**Consultation Response from KC,
Highways Development Management**

2026/90765 321, Halifax Road, Hightown, Liversedge, WF15 6NE

Erection of two storey side extension and detached garage with associated alterations

Responding Ref: 9-4NW/16

**DRAWING TITLE**  
Site Location Plan and Proposed Site Plan

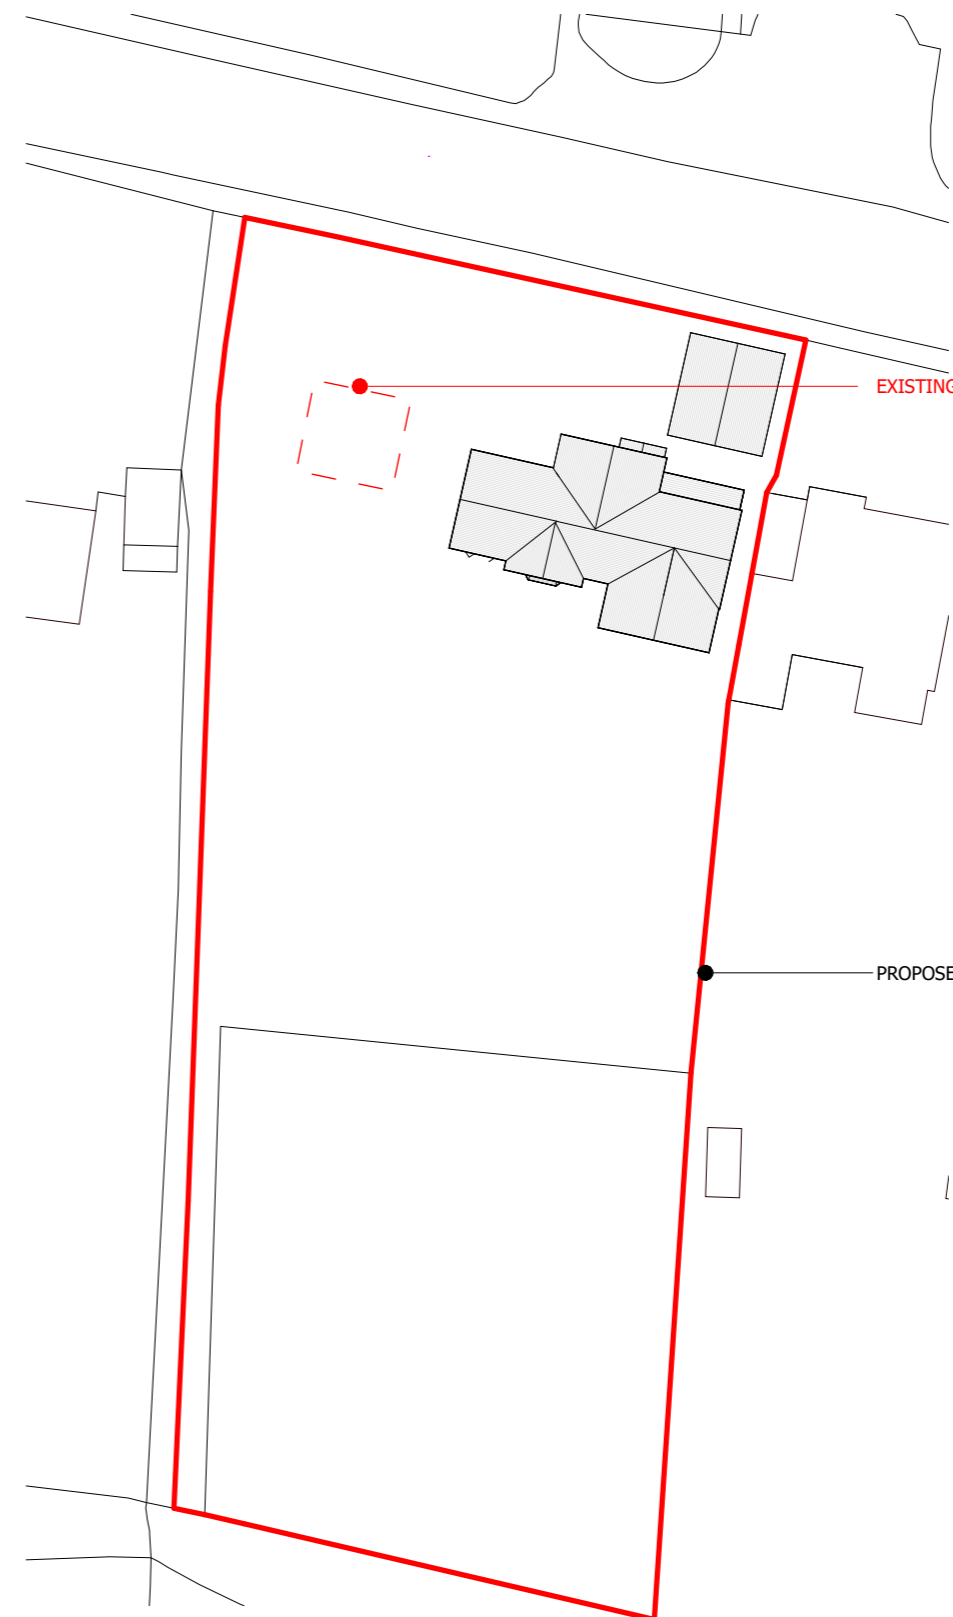
The proposal would increase the number of bedrooms from three to five. It retains the existing access, driveway, hardstanding, double garage, and bin storage, and includes a new double garage.

The intended garage is of adequate internal size to serve as a double with sufficient space in advance of the doors for manoeuvring and / or additional parking and internally for car parking and storage of cycles or other items.

There would remain more than enough car parking on-site on increasing the number of bedrooms given the amount of driveway / hardstanding space plus existing and additional garage space. Three car parking spaces being the norm for four plus dwellings as advised by the Kirklees Highway Design Guide SPD.
